NSW Government Architect Response

RE: Development Application for Proposed Construction of Nine-Storey Mixed Use Development at 42 Honeysuckle Drive, Newcastle NSW 2300

As a result of the public exhibition process of State Significant Development (SSD 8440) a submission was received from the NSW Government Architect.

4.3 HOTEL COMMUNAL SPACES - CORNER ACTIVATION

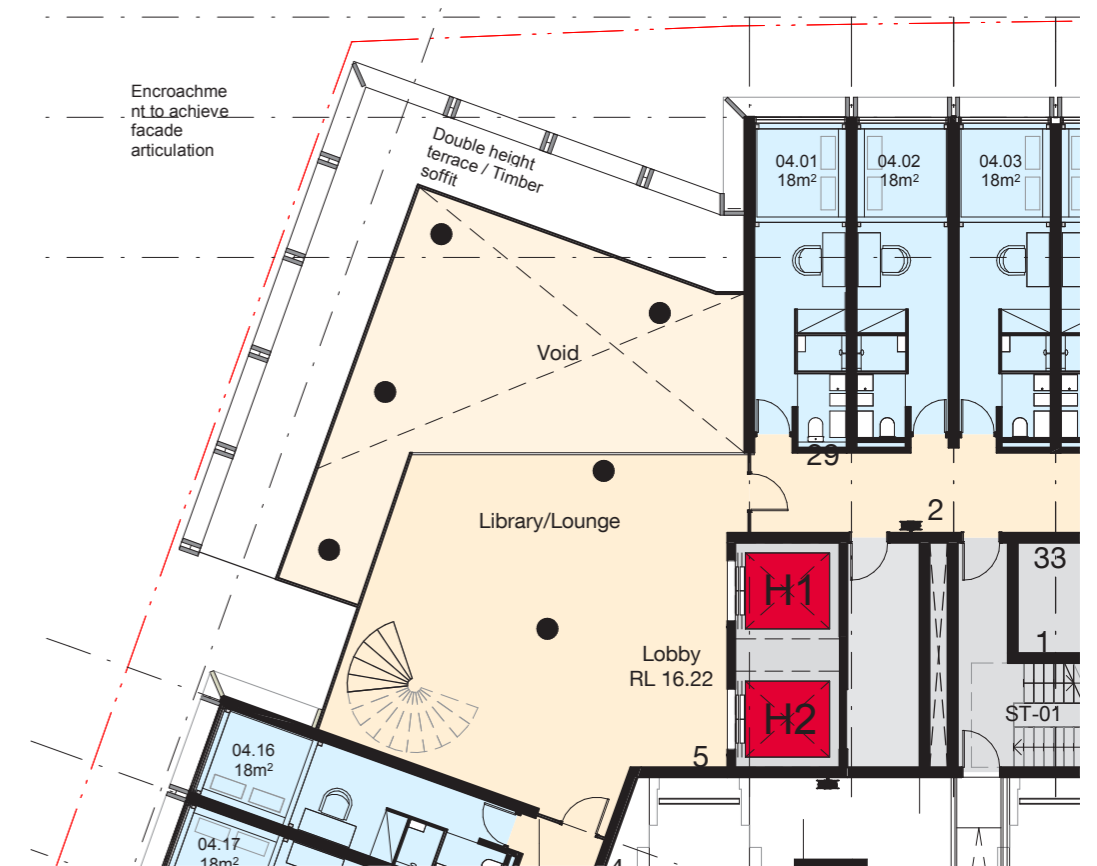
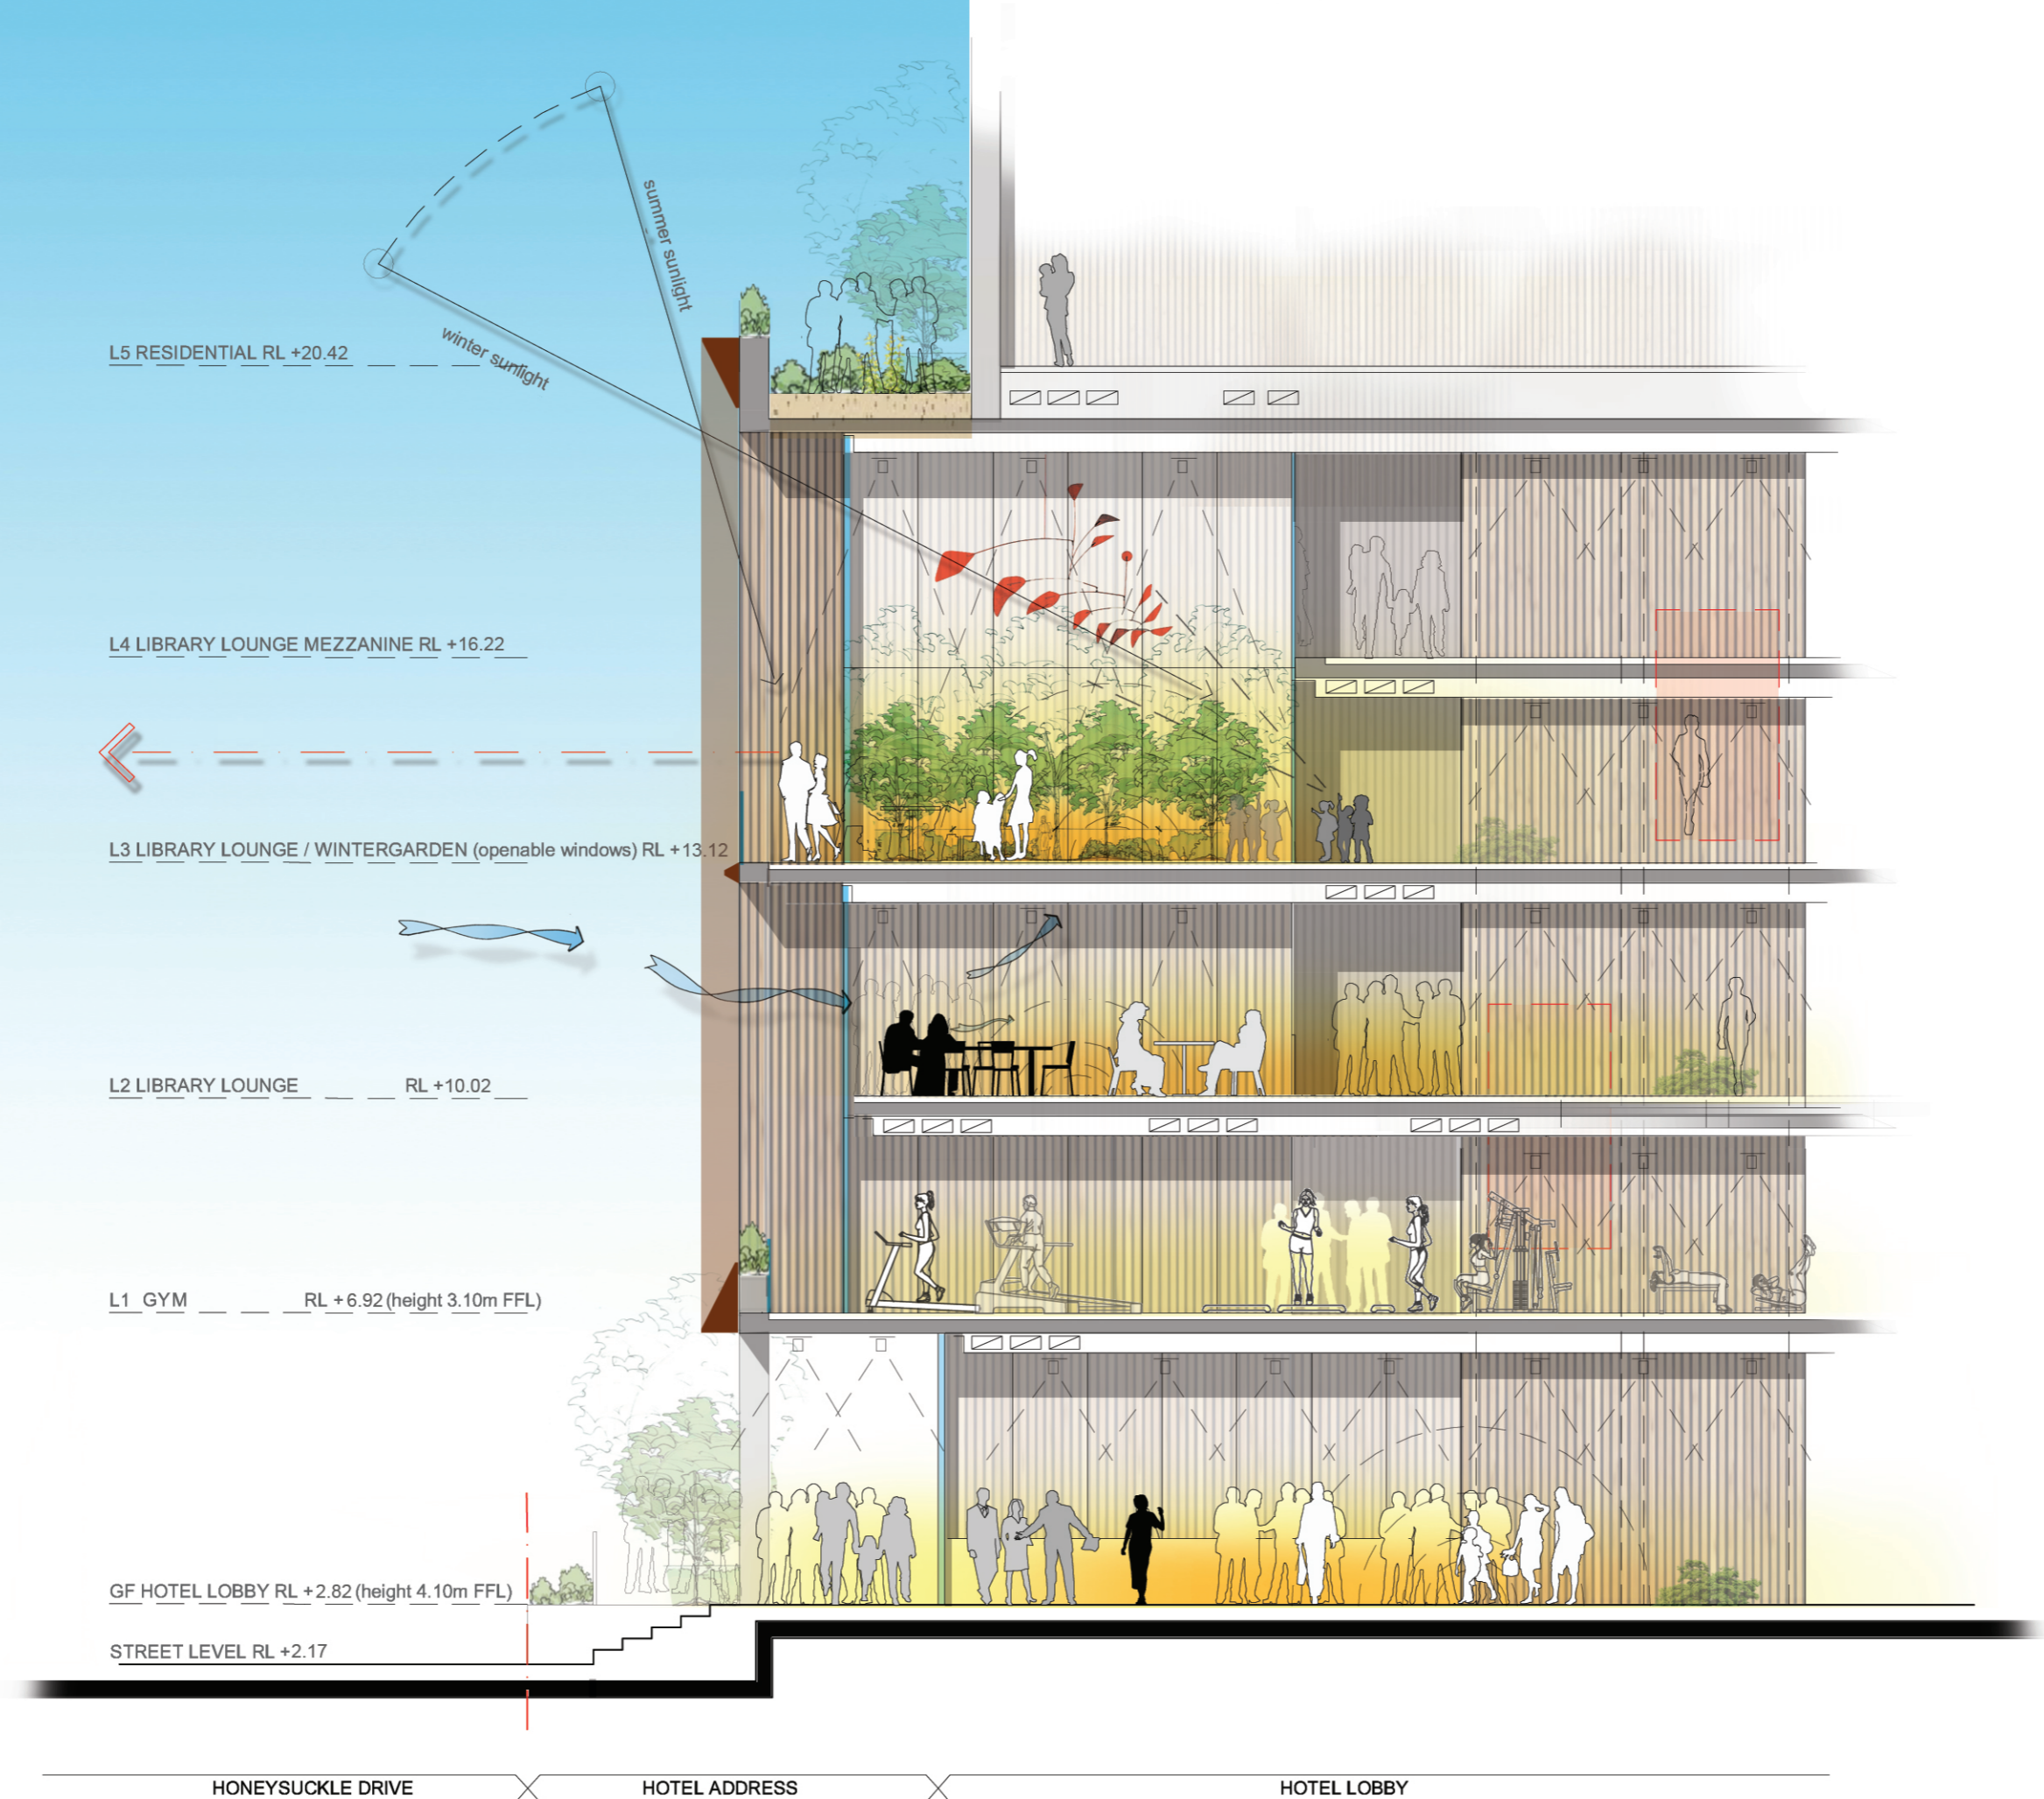
- *Provide the opportunity for natural ventilation to the hotel rooms and communal hotel spaces including lounge, gym and food and beverage areas.*

The hotel communal spaces situated at the North West corner of the site positioned above the entry has a guillotine type window at levels 2 and 3 with a double height space behind which will provide natural ventilation through the space.
